Ribble Valley Borough Council
Council Offices
Church Walk,
Clitheroe
Lancashire
BB7 2RA

Phone: 0300 123 6780
Email: Kathryn.Walsh@lancashire.gov.uk
Your ref: 3/2025/0930
Our ref: 3/2025/0930/HDC/KW
Date: 23 February 2026

Location: Bolton Fold Farm Alston Lane Longridge PR3 3BN
Proposal: Proposed erection of 2 no. self-build agricultural workers dwellings with access and parking.
Grid Ref: 360137 435333

## Appendix D

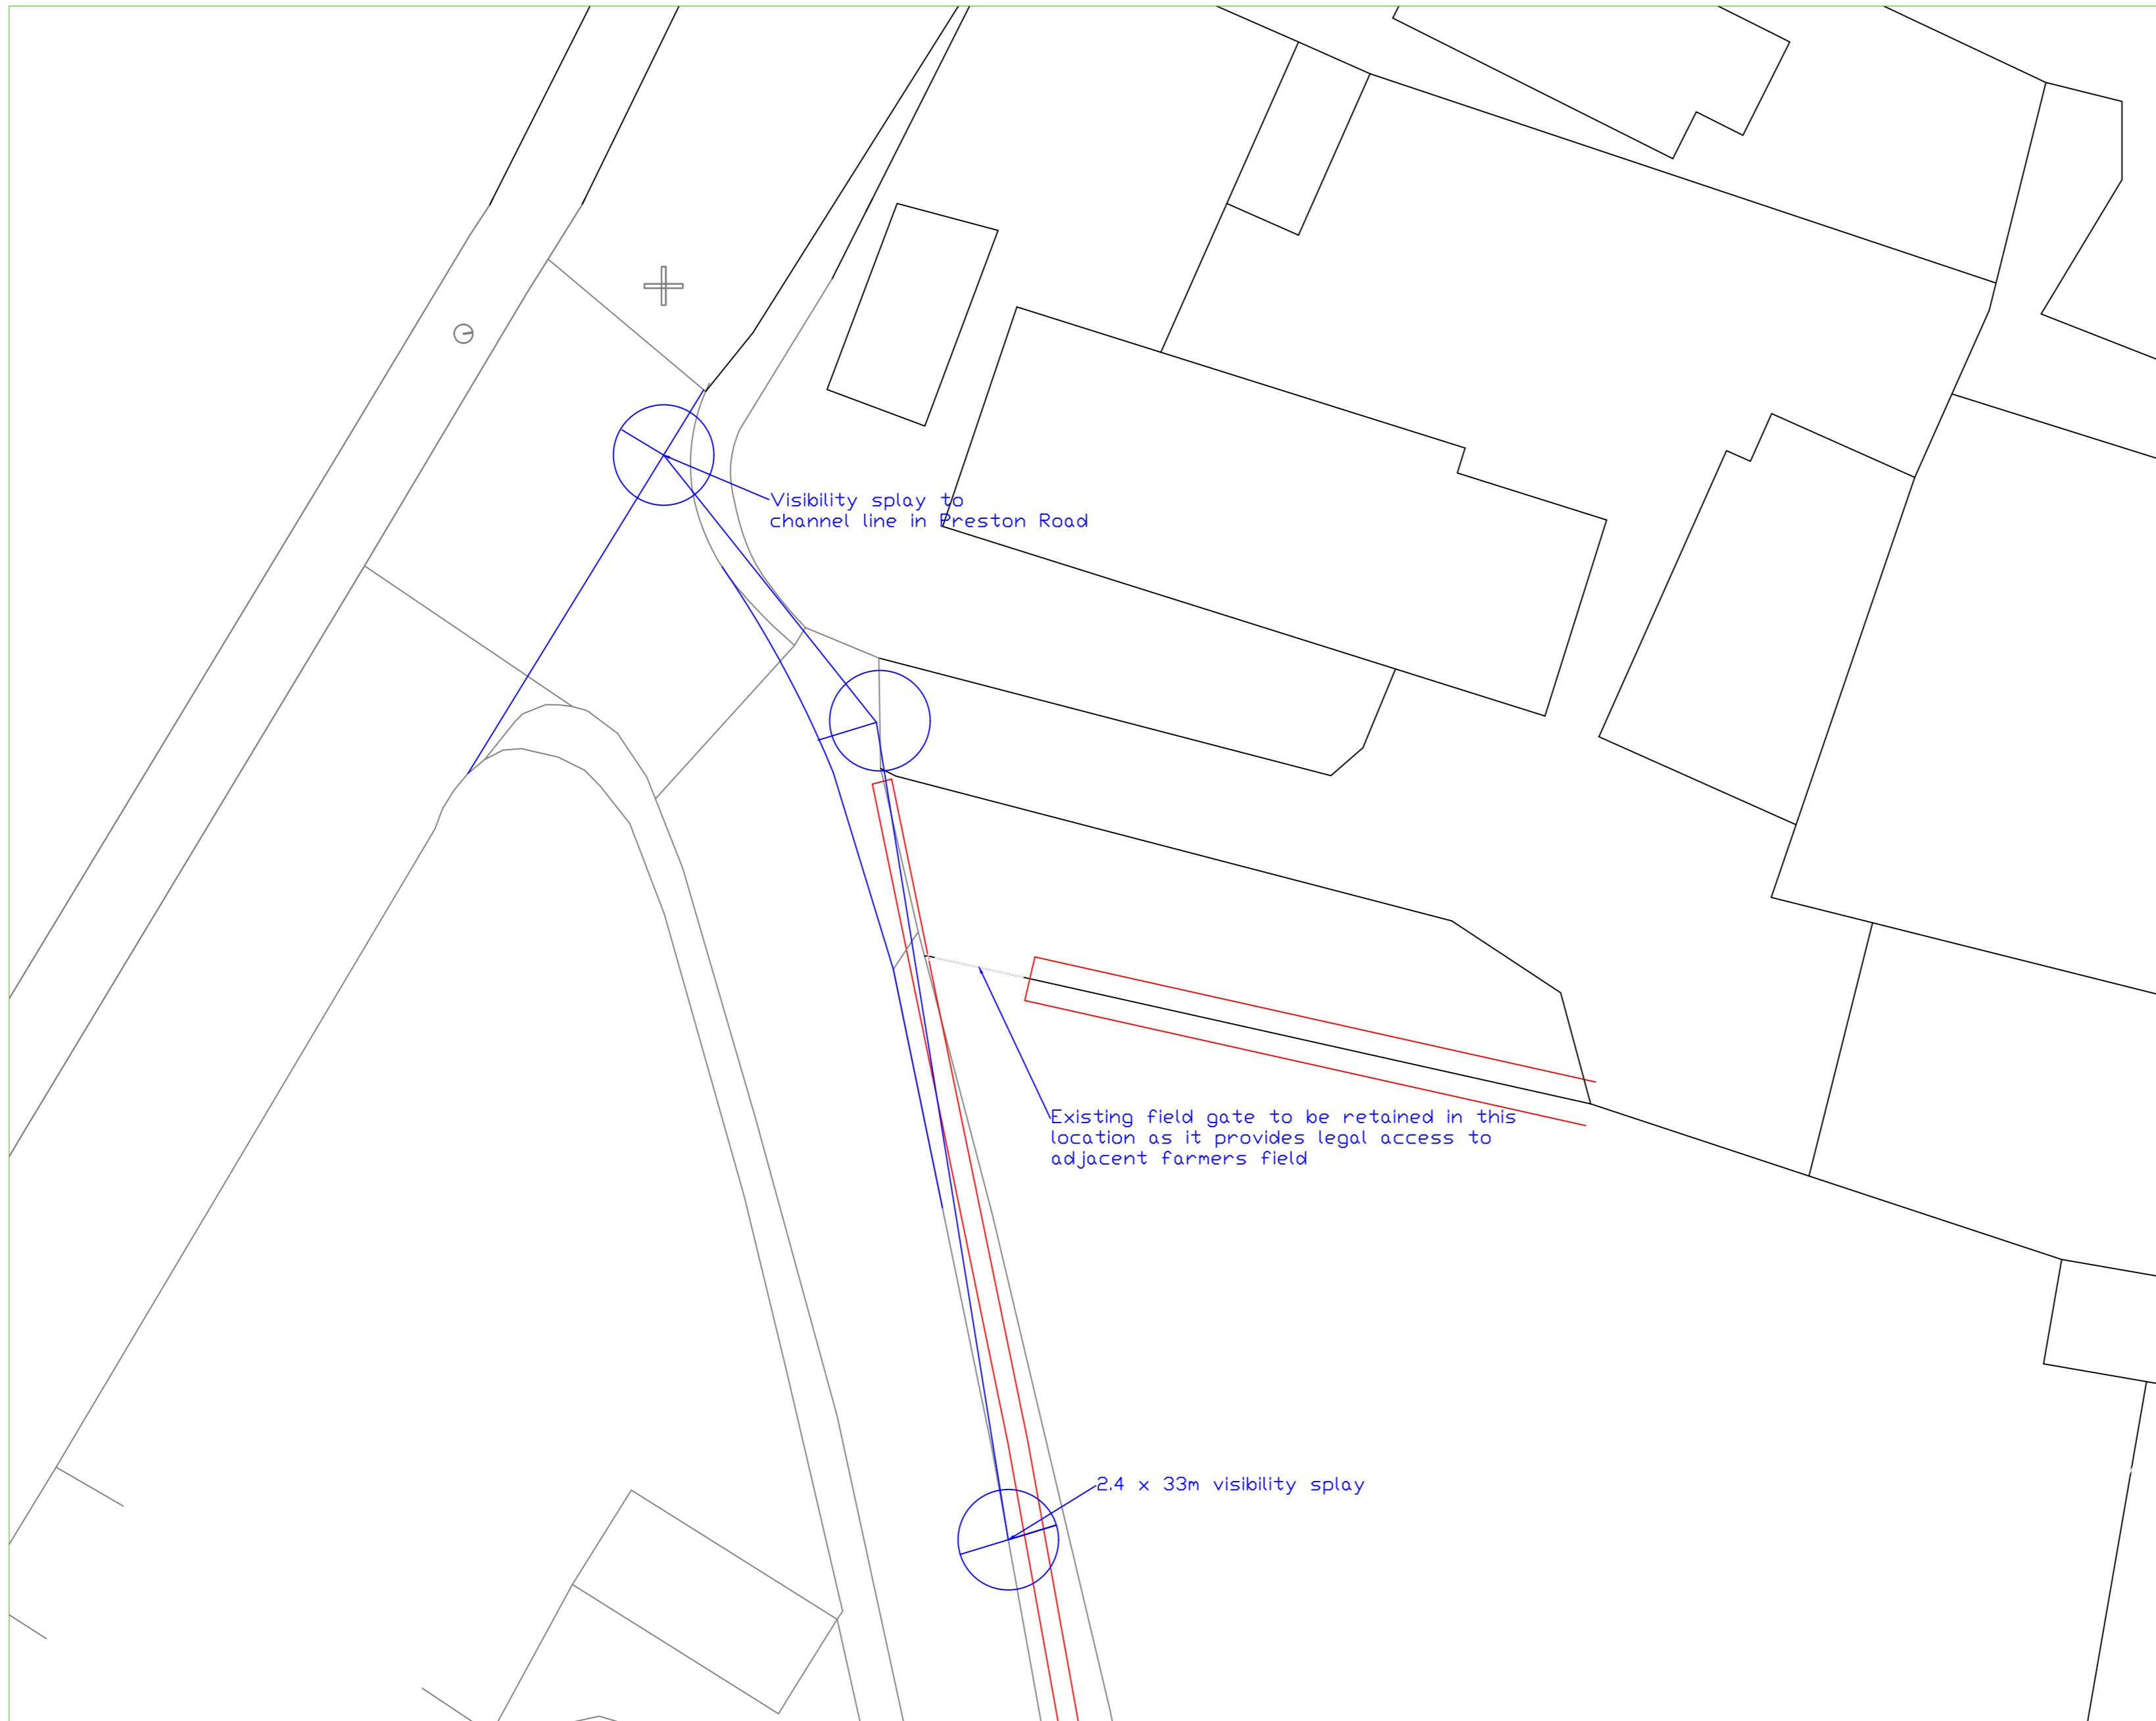
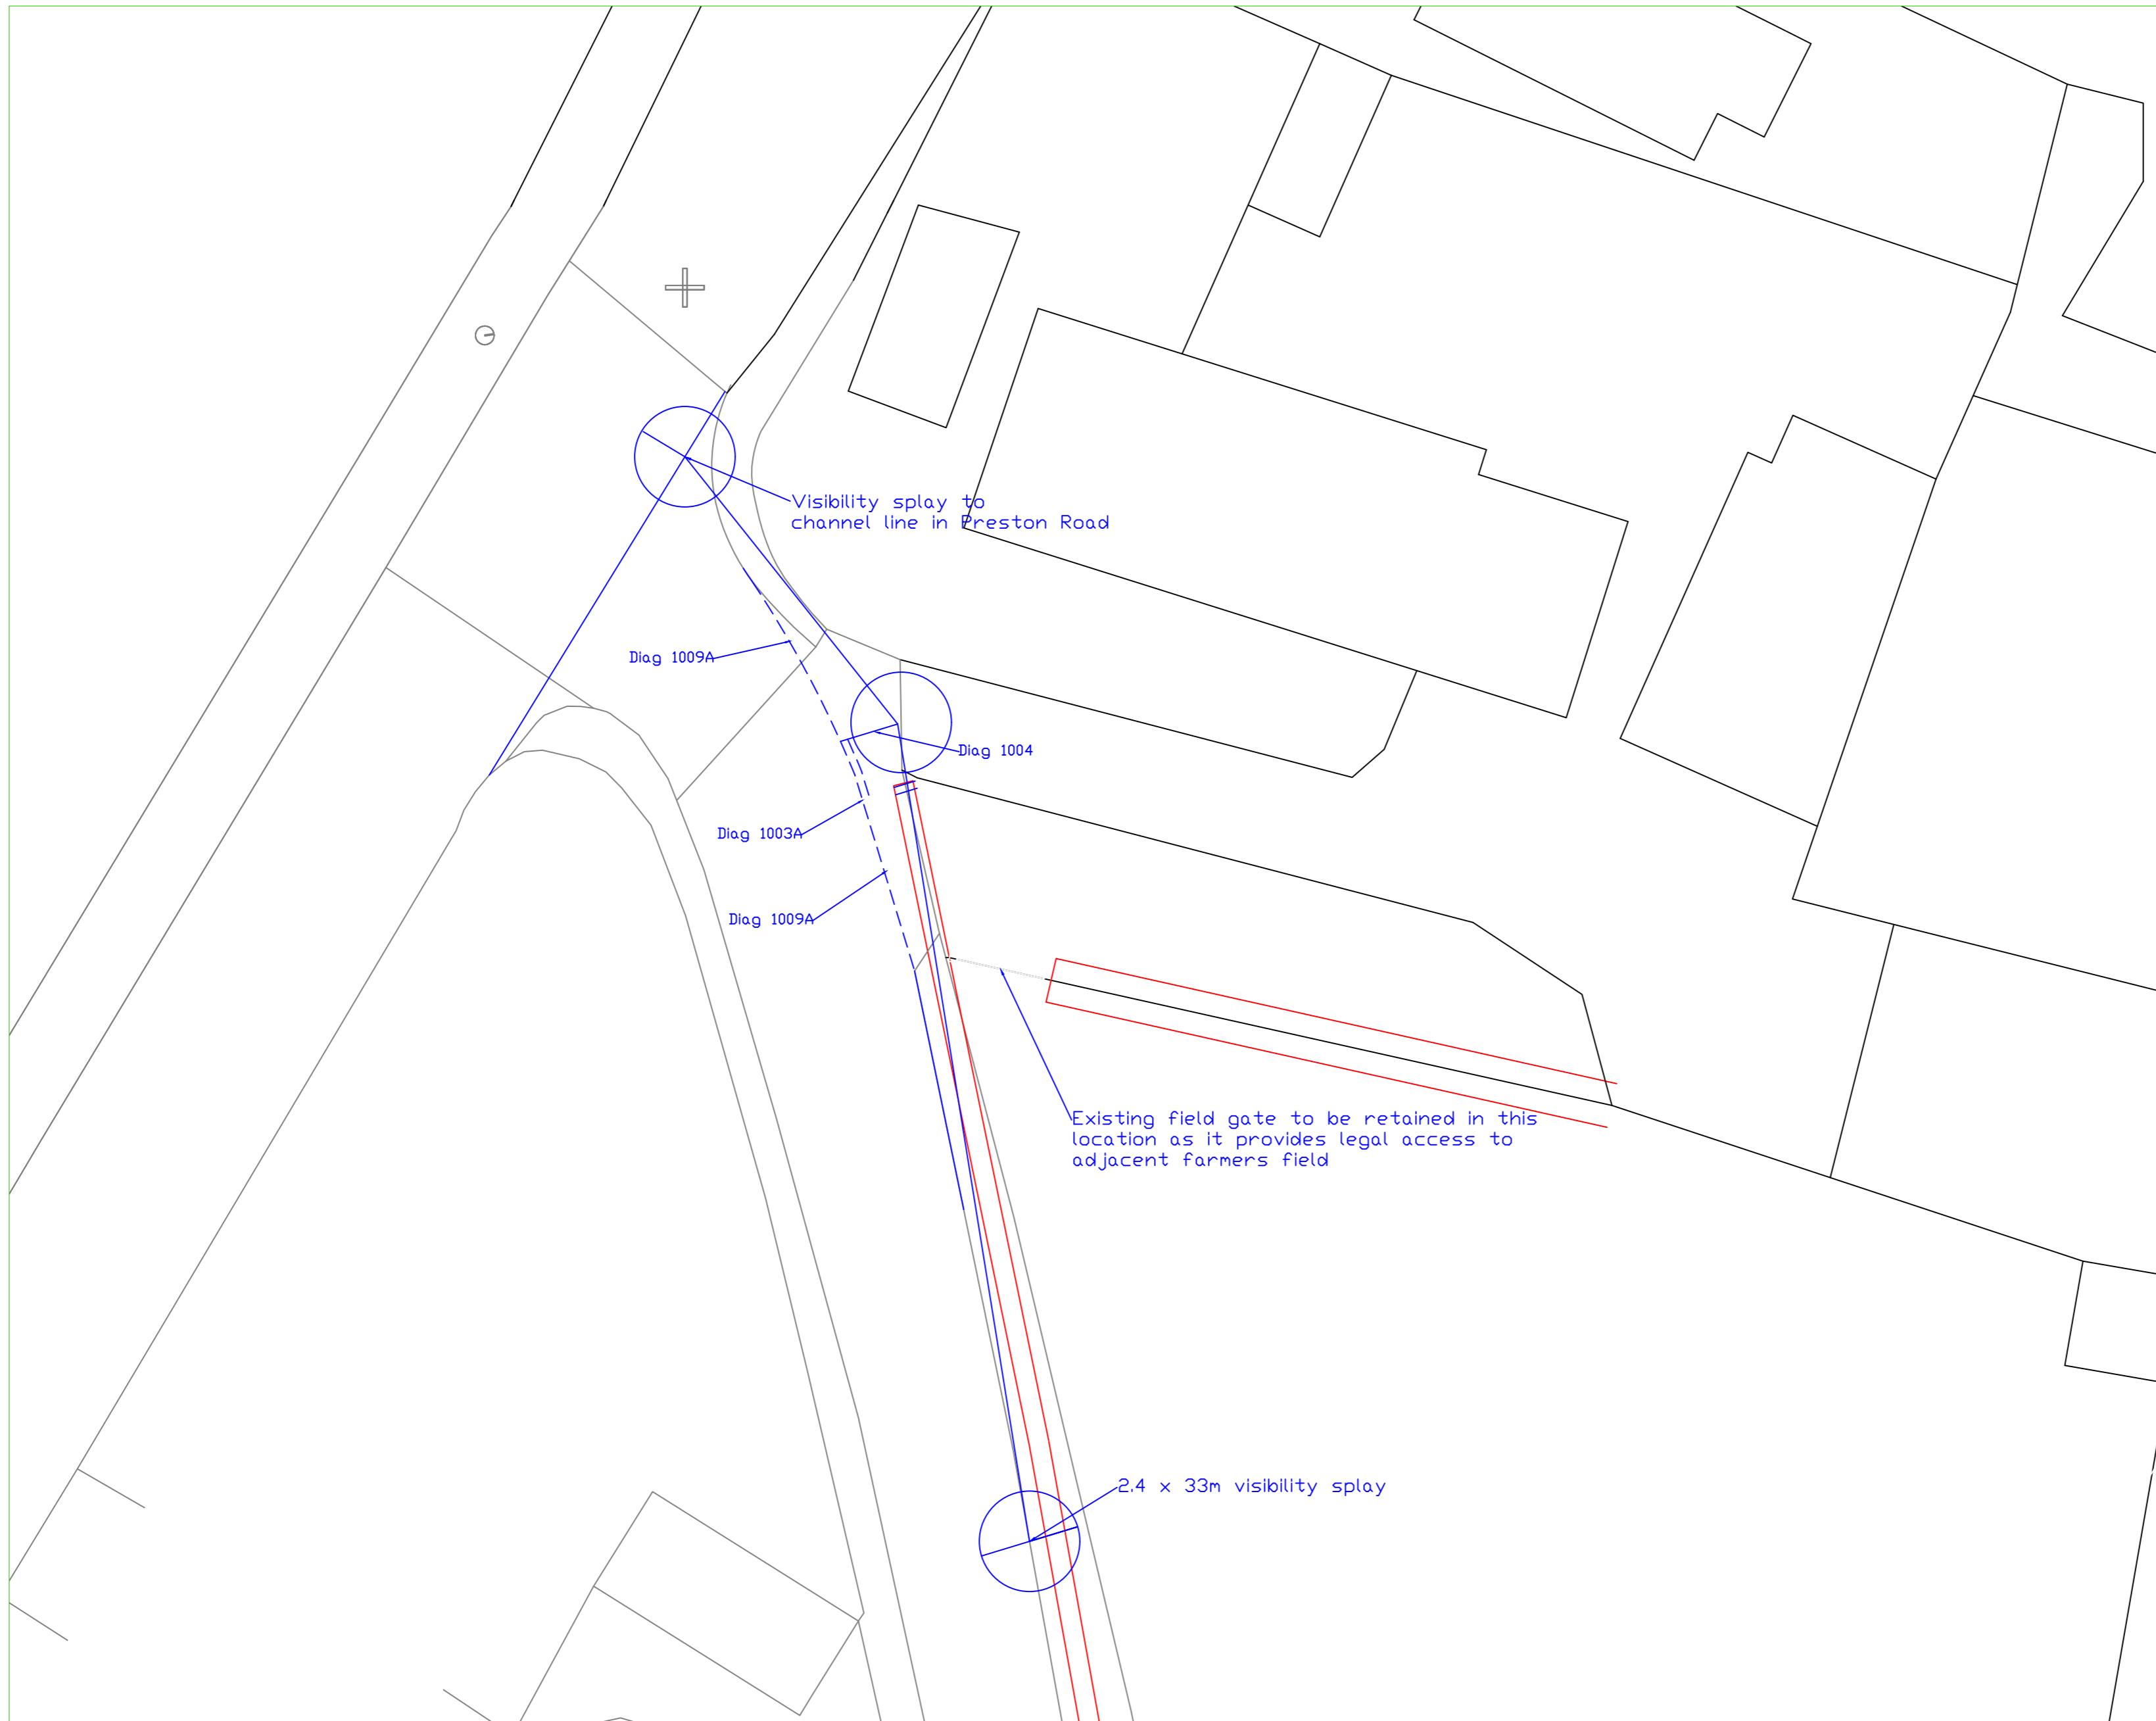
The LHA have reviewed the Proposed Site Plan, drawing PSP 001 REV E and are aware that the dwellings parking area complies with the LHAs parking standards as defined in the Joint Lancashire Structure Plan. The area is able to provide off street parking spaces for each dwelling as well as appropriate manoeuvring room.

The recommended minimum internal dimensions for a single garage size is 6m in length and 3m wide. The recommended distance of 6m is based on the length of a large family car (Ford Mondeo Estate 4.58m long), clearance at the rear of the car (200mm), overhang of the garage door (600mm) and room to stand in front of the car and open/close the garage door (600mm). The LHA has reviewed the proposed floor plans for both agricultural dwellings, drawing PRO 001 REV D and PRO 002 REV D and note that the garages have been designed to an acceptable internal size to provide parking.
